Our Ref: BR/154/12/
Your Ref:

Application for Planning Permission for Works or Extension to a Dwelling

Development Extension to rear of property
Location 93 Orchard Way Bognor Regis

93 Orchard Way

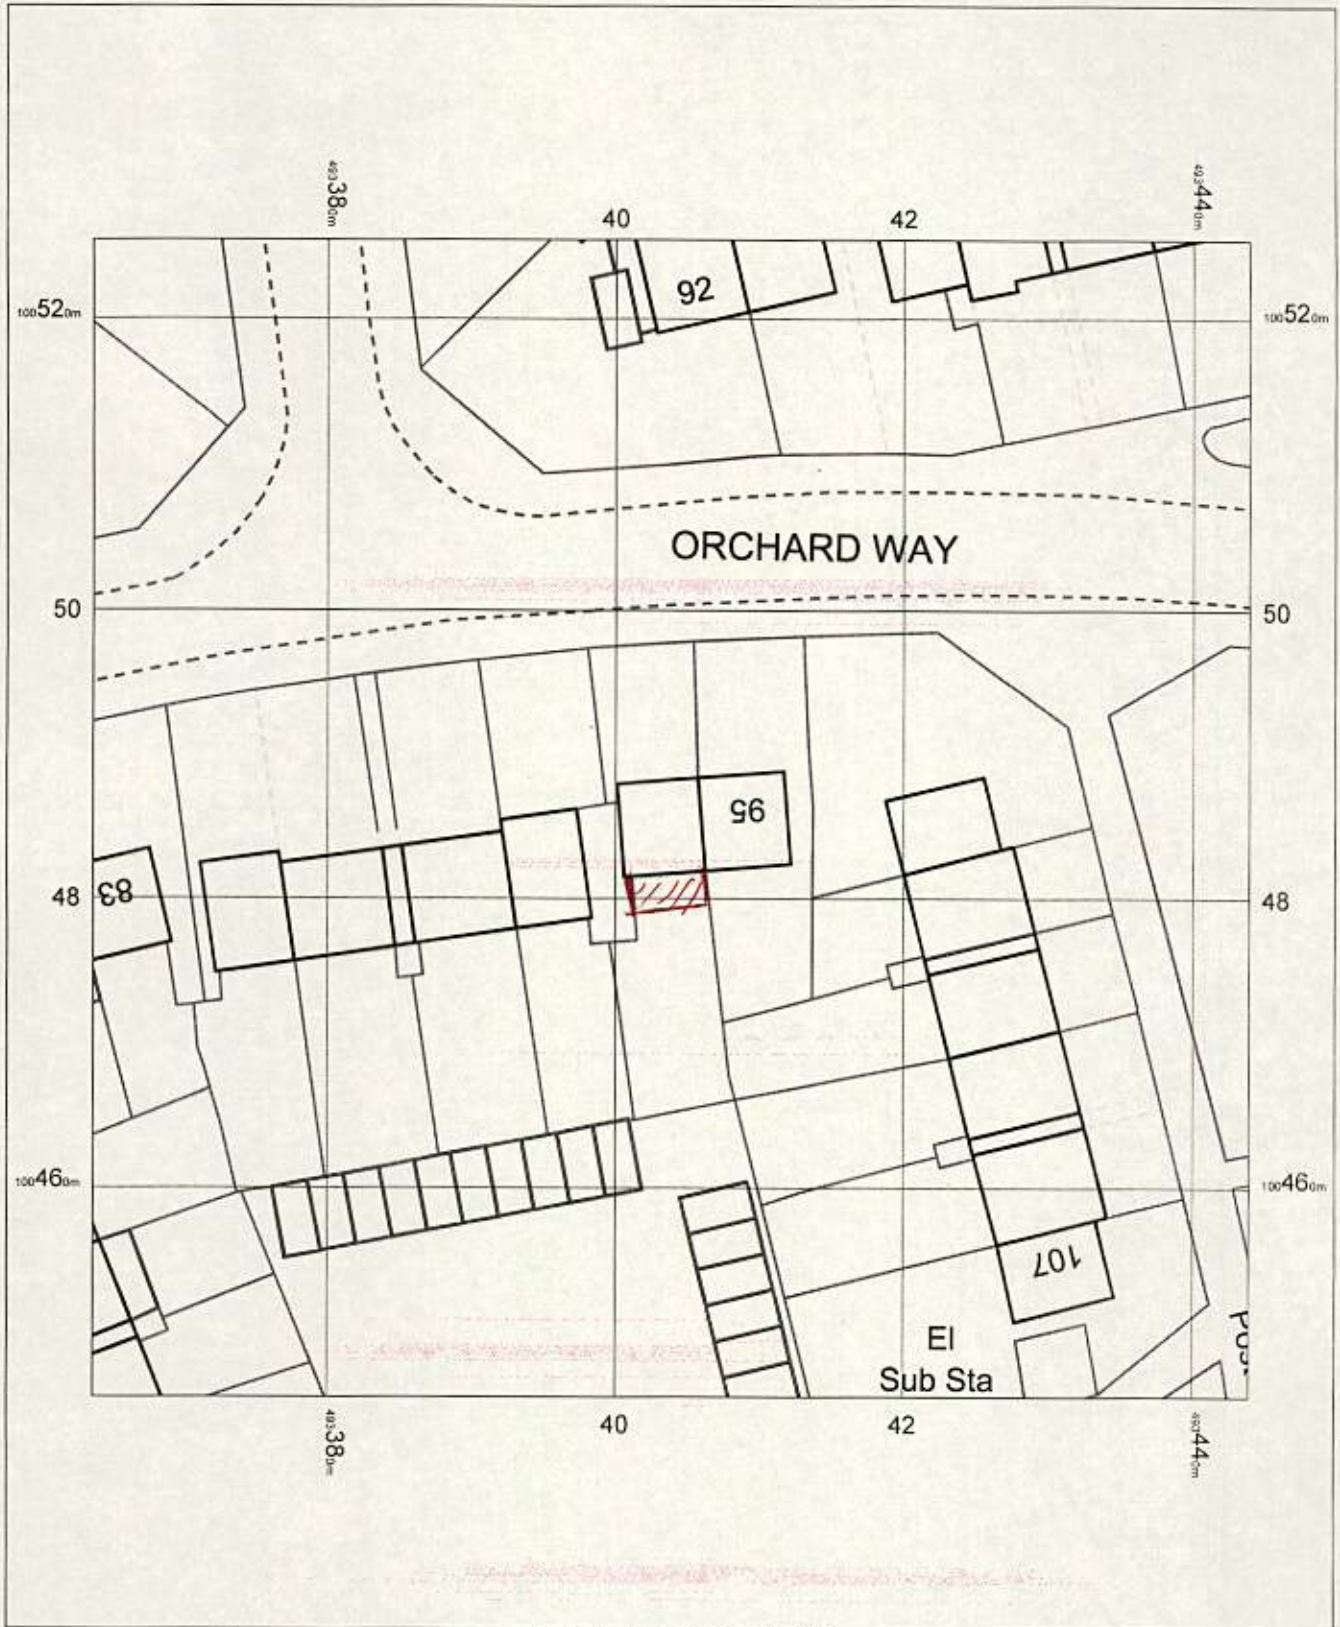
The submitted block plans appear to be photocopies from Ordnance Survey maps. Please verify in writing that you hold a Business Use Licence, which allows you to make copies of maps under the Map Return Scheme or alternatively submit 1 electronic or 3 paper copies of amended location plans.

Existing & Proposed Elevations & Plans.

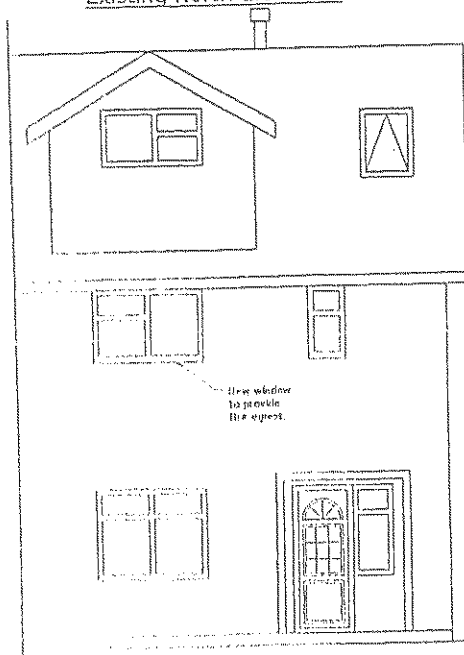
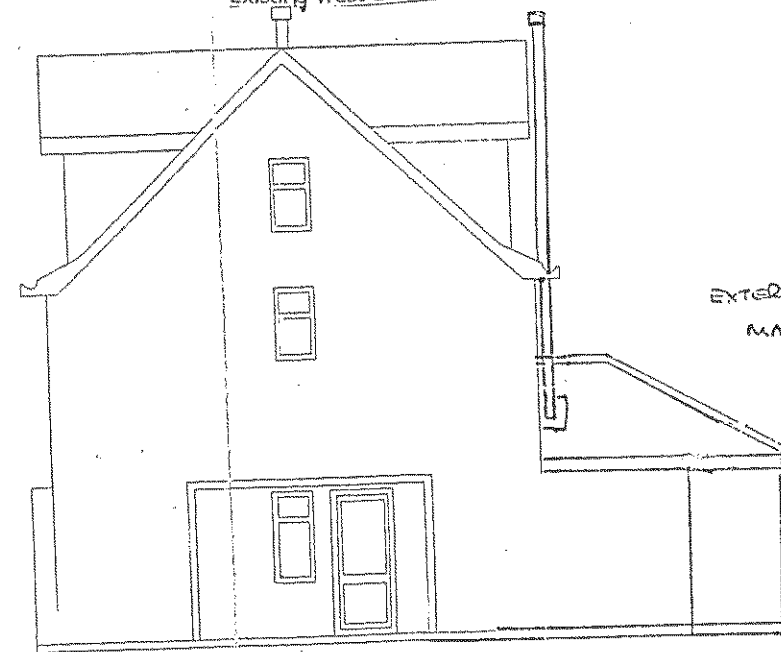
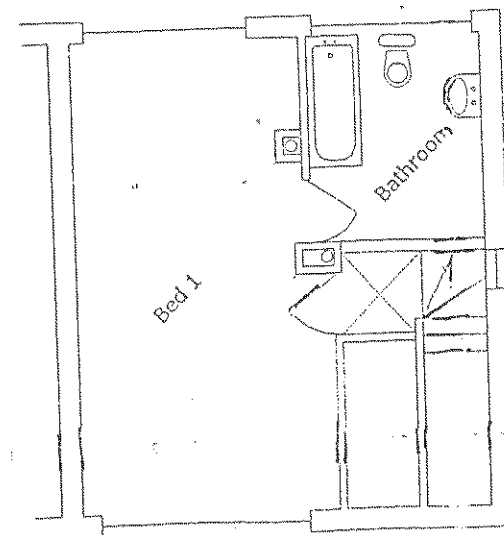
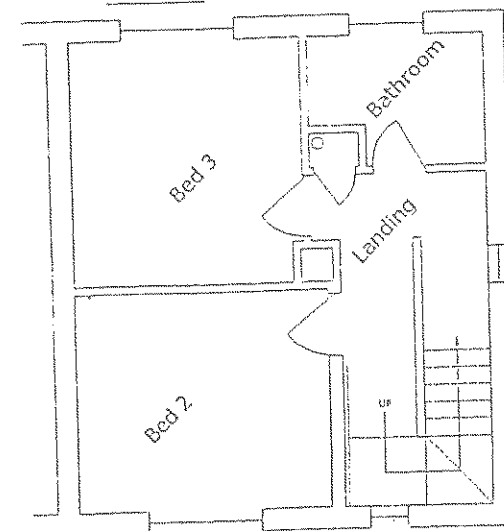
Please provide 1 electronic or 3 paper copies of amended existing west and south floor plans and elevations at a scale of 1:50, as the plans submitted do not coincide, in accordance with the guidance notes available on our website detailed below (click on National List).

Please provide 1 electronic or 3 paper copies of revised proposed north floor plans and elevations in accordance with the guidance notes available on our website detailed below (click on National List). You have indicated on the North elevation that there is to be a proposed Velux however, you have omitted to show this on a floor plan or include this in your description. If the velux forms part of the application then please amend the description and include a floor plan, if it not then please remove it from the North elevation.
